Memorandum
Planning and Urban Development Department
Planning Division

Date: February 23, 2018

Re: MMC East Tower and Visitor Garage Vertical Expansion
 22 Bramhall Street
 Maine Medical Center (MMC)

Project #: 2017-289 CBL: 053D007/054H001/064C001

[ Logistics Plans and Studies ]  
East Towers and Visitors Garage

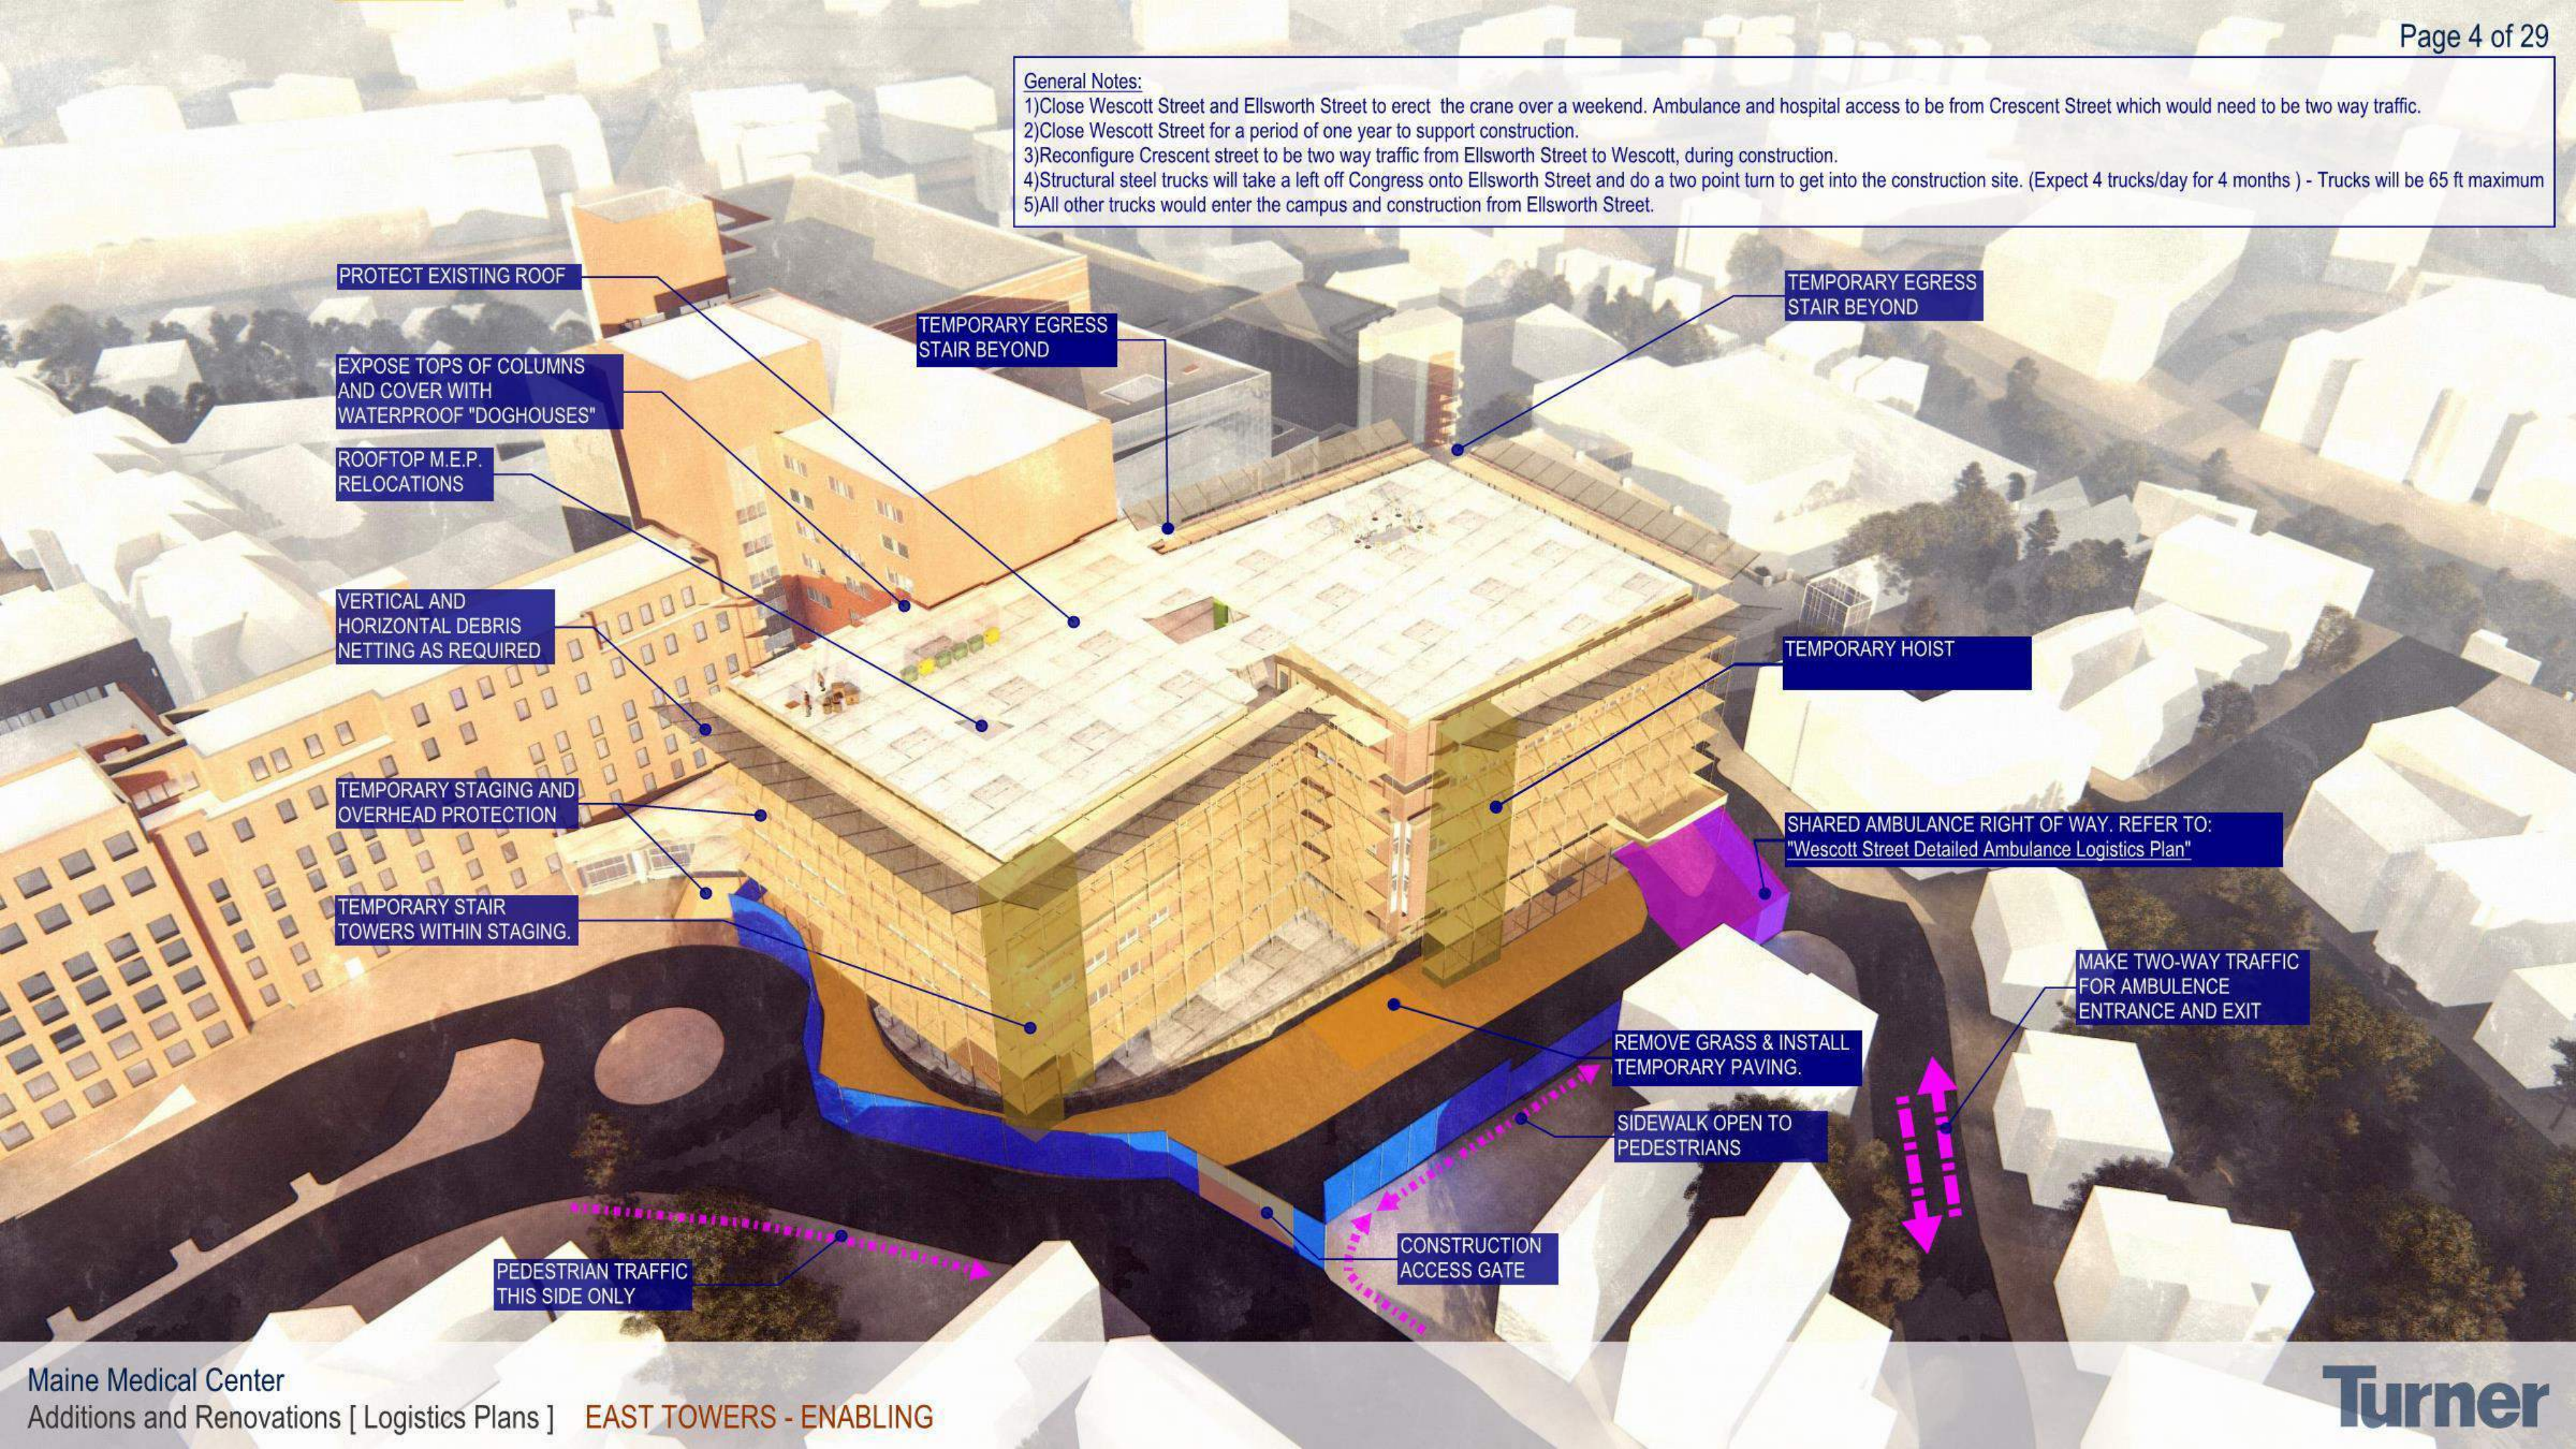
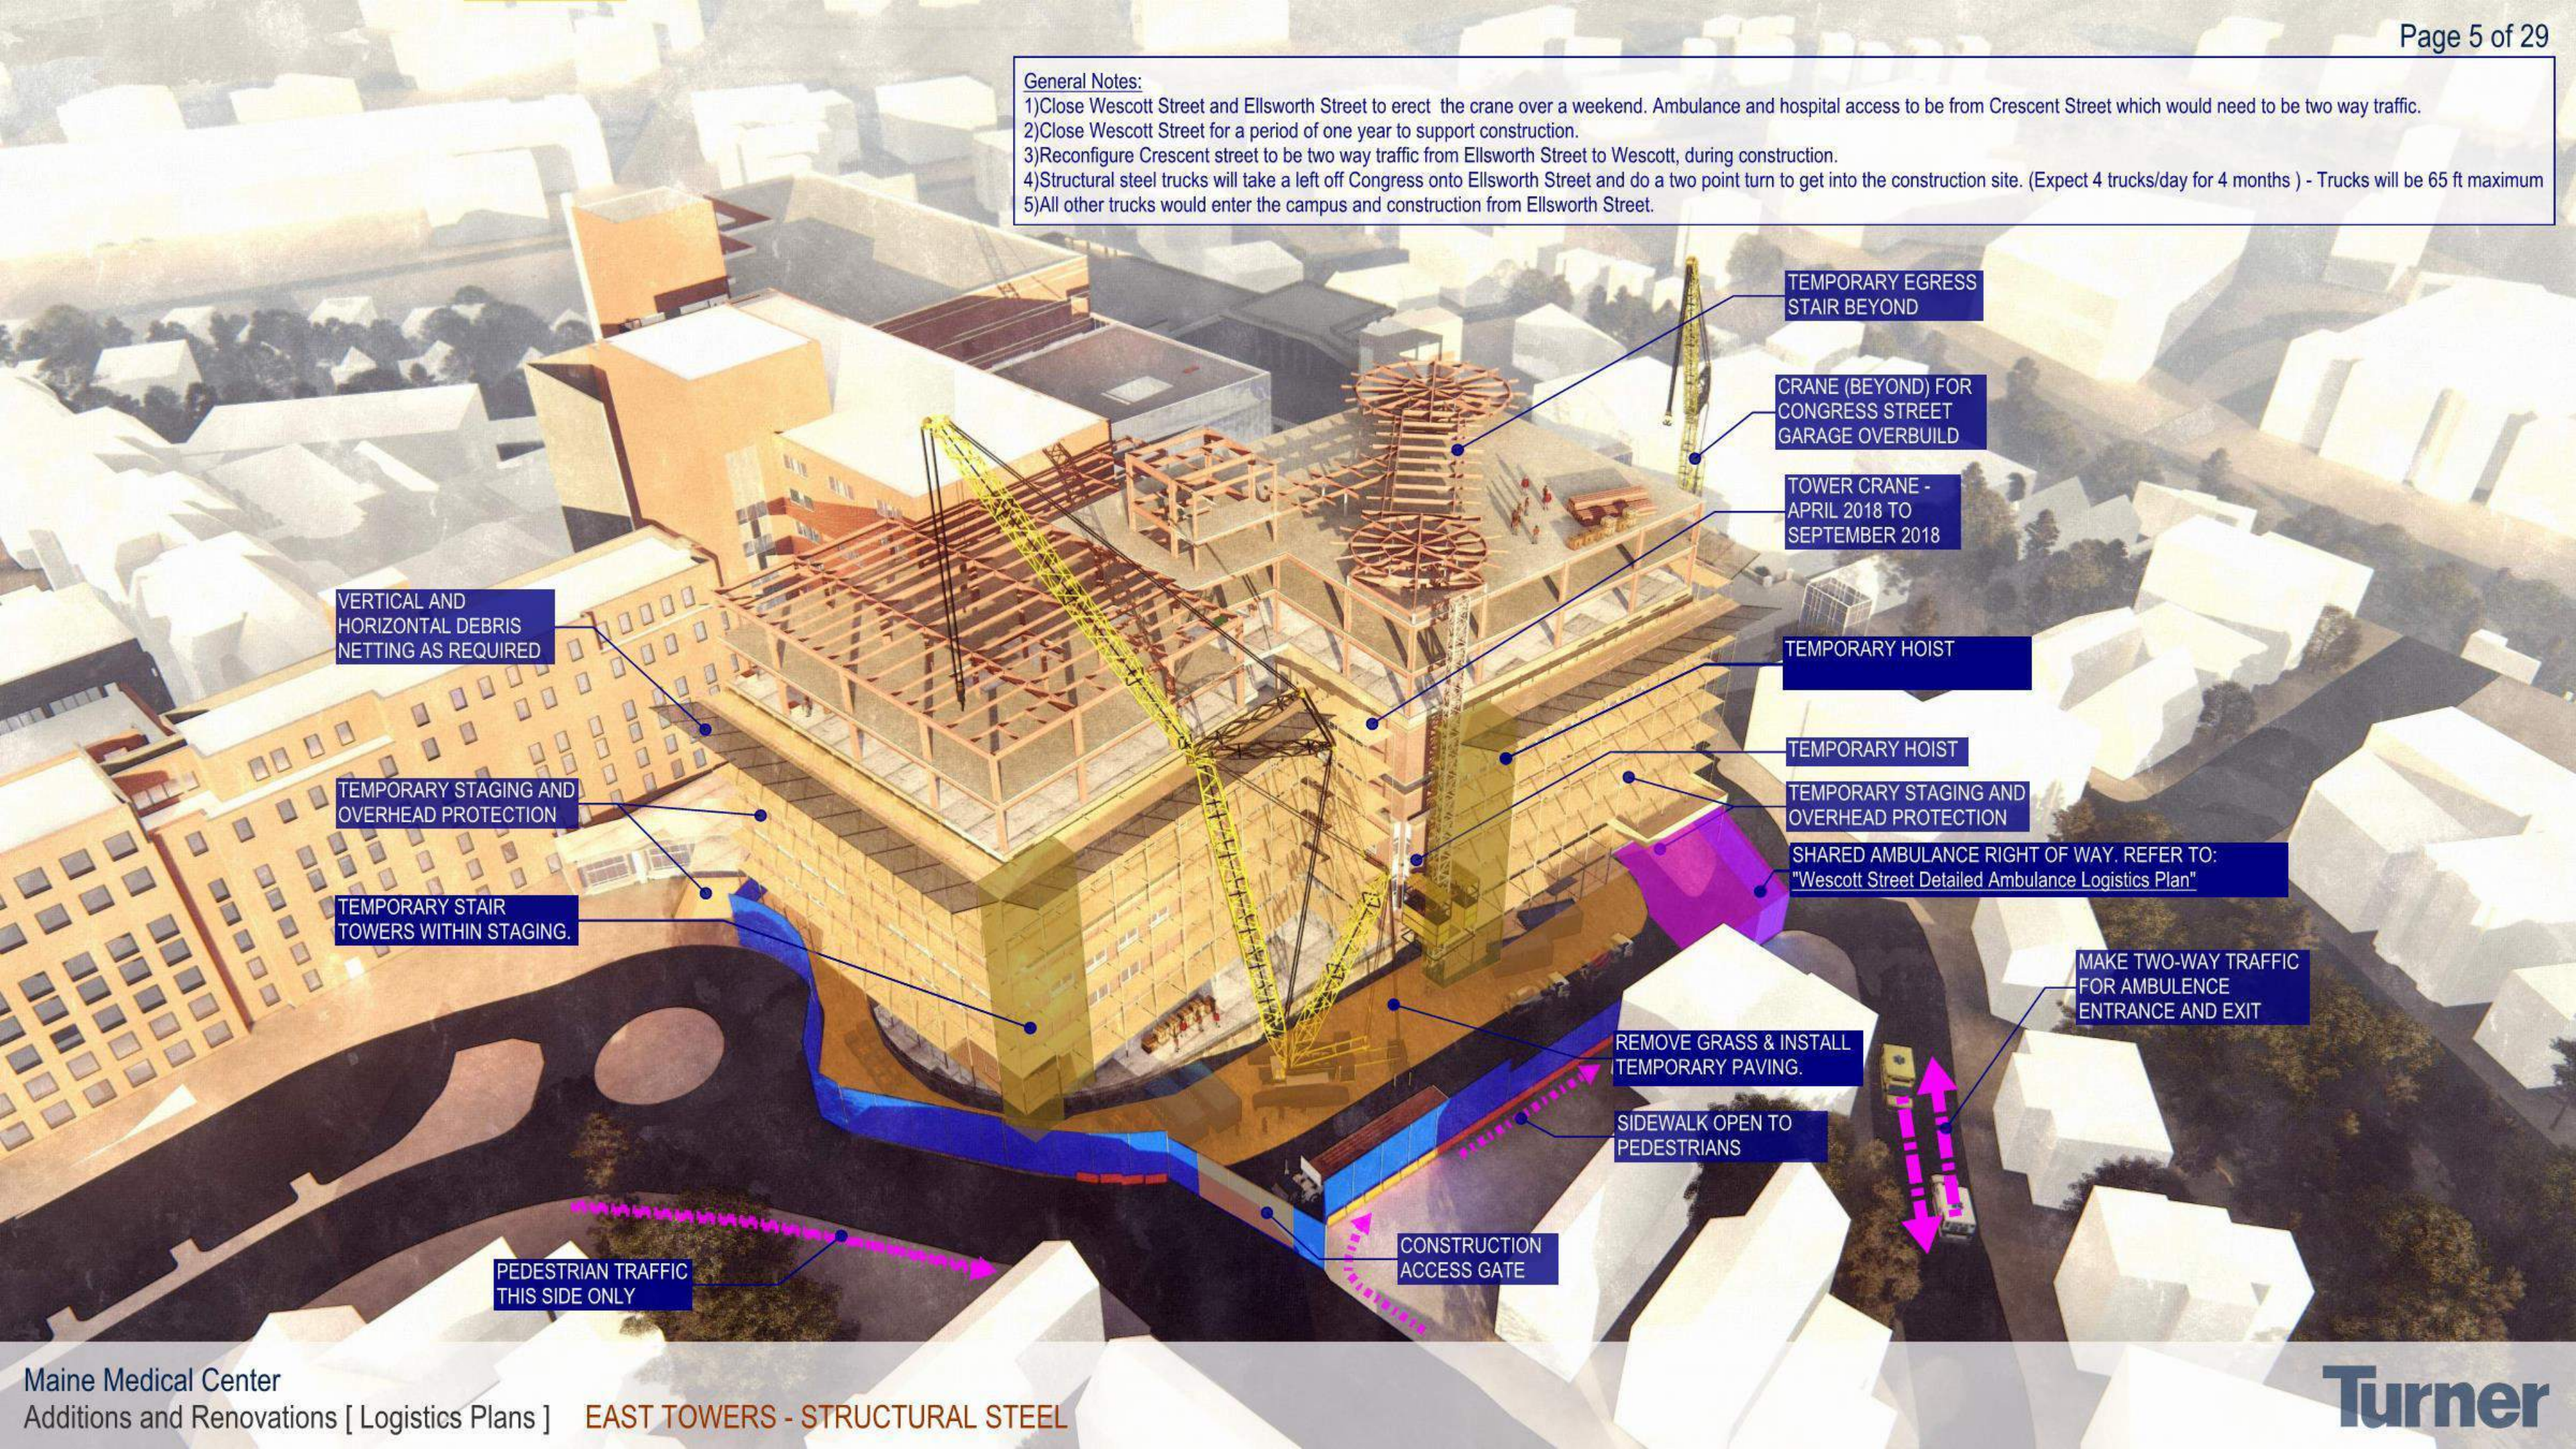
Since the first PB Workshop MMC and Turner has submitted a revised CMP (Second Workshop Plan WSI-5 CM Plan) that has been revised as follows:

- Access for ambulances has been revised to remain as existing by relocating the site fencing and modifying the curb to provide ambulance access to the bays under East Tower
- References to converting Ellsworth to two way have been removed
- Precast and steel delivery routes added
- Location of concrete washout areas added per Wright Pierce Peer Engineer comments (Att. 9, 1.25.18)
